From: Simon Davis
Sent: 06 June 2013 08:48
To: [REDACTED]
Subject: RE: Conservatory & Dbl Garage at Redtile Cottage Ref AL/31/13

I have just been writing this application up but in doing so I had cause to measure the proposed elements from the plans. Unfortunately, I cannot measure any heights as your Sheet 2 Proposals Plan is not to the correct scale of 1:50. For instance, measuring the height of the property's front door gives me only 1.4m. My guess is that the original plan has been reduced/photocopied and this is why the scale is now wrong.

PROPOSED DOUBLE GARAGE AND CONSERVATORY EXTENSIONS AT "REDTILE COTTAGE" BRITENS LANE, FONTWELL, BN 18 0ST. FOR MR K. LOCKYEAR. SCALES AS ANNOTATED. APRIL 2013.

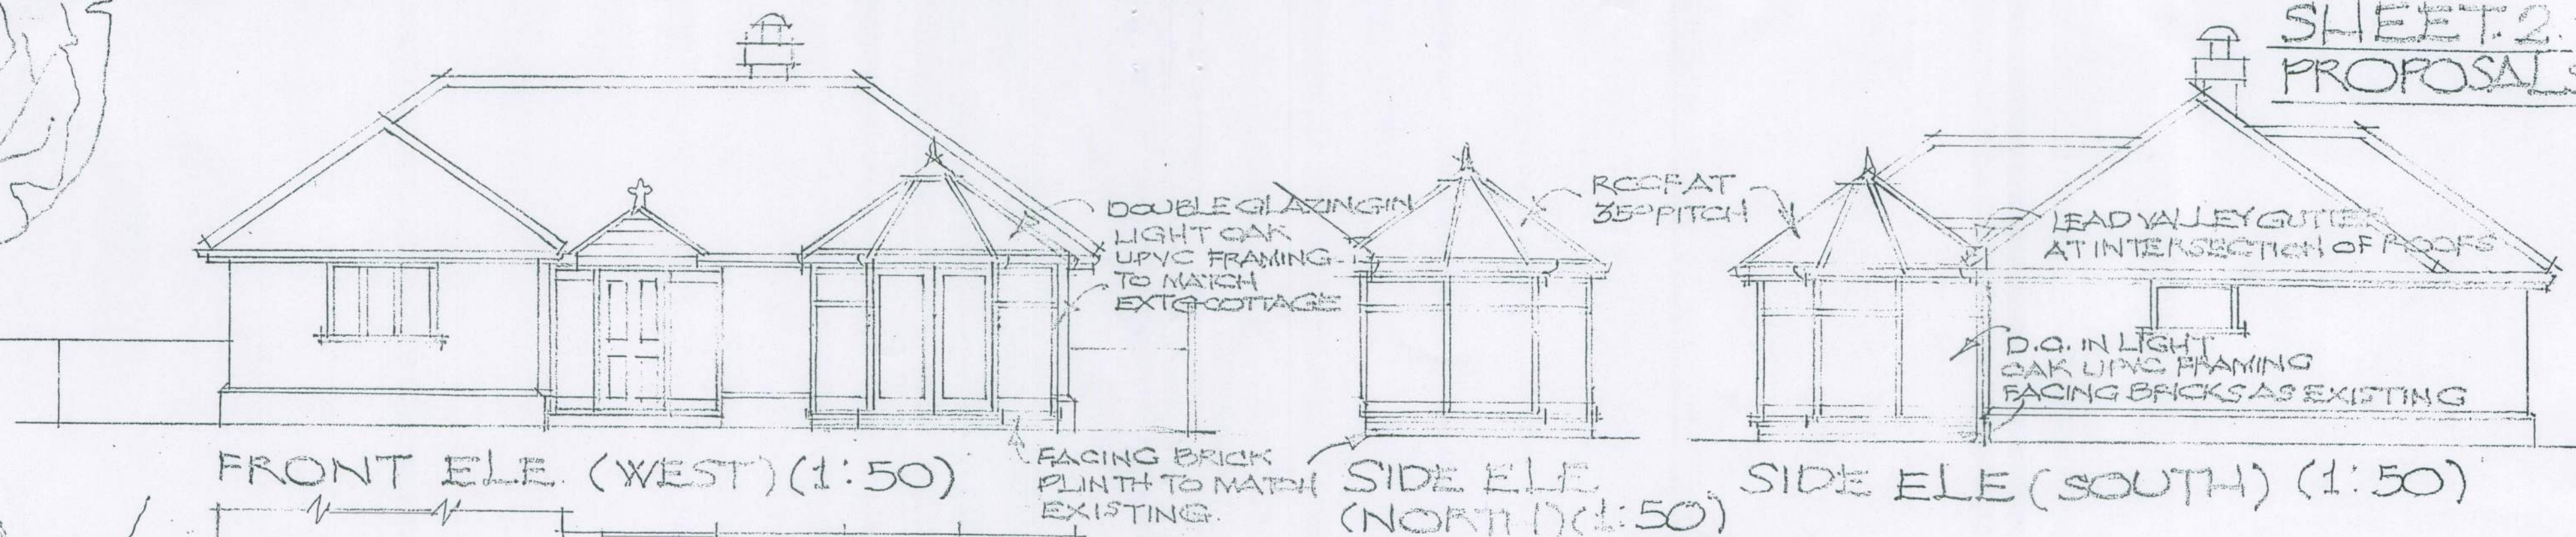
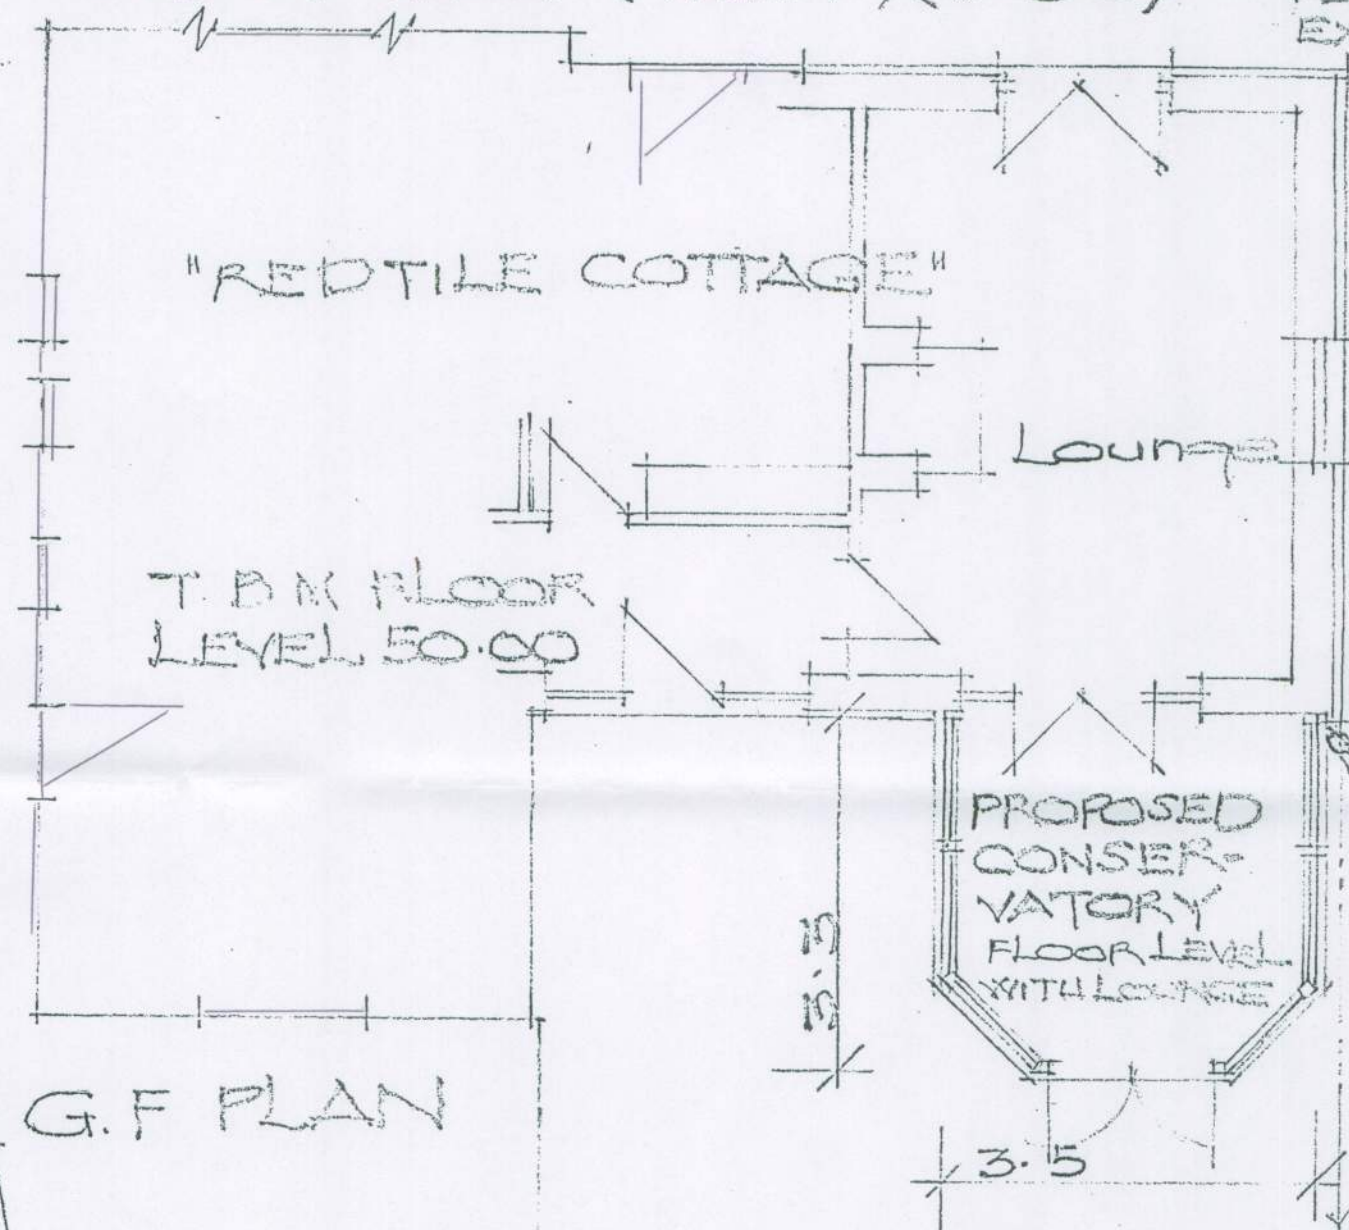
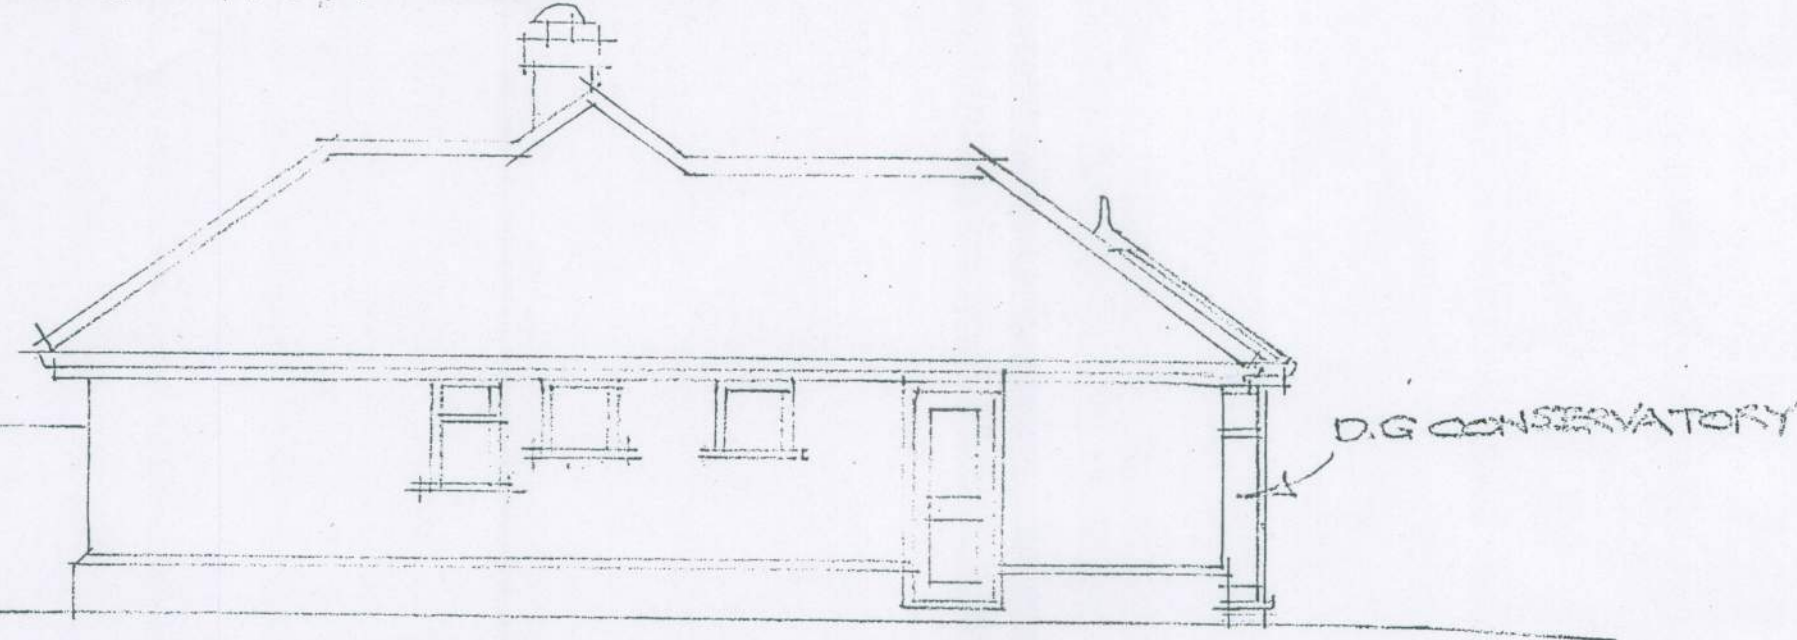
In order for me to determine this application favourably I need you to either (a) supply a new version of the plan at the correct scale or (b) simply amend the existing drawing by adding the heights in respect of the proposed conservatory and double garage (i.e. the total height and eaves heights).
